**STAGE 2A – NORTH PENRITH MIXED USE DEVELOPMENT (SSD5243)  
AT THE CRESCENT, NORTH PENRITH**

I refer to your letter of 3 August 2012 (Department Ref: SSD 5243) concerning the abovementioned State Significant Development which was referred to Roads and Maritime Services (RMS) for comment in accordance with Clause 104 of *State Environmental Planning Policy (Infrastructure) 2007*.

9.9m Garbage Truck      meters

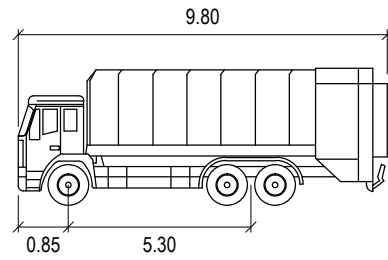
6. The swept path of the longest vehicle (including garbage trucks) entering and exiting the subject site, as well as manoeuvrability through the site, shall be in accordance with AUSTROADS. In this regard, a plan shall be submitted to Council for approval, which shows that the proposed development complies with this requirement.
7. All access roads and internal roads of the proposed subdivision are to be designed in accordance with AUSTROADS, the relevant Australian Standards and RMS Supplements.
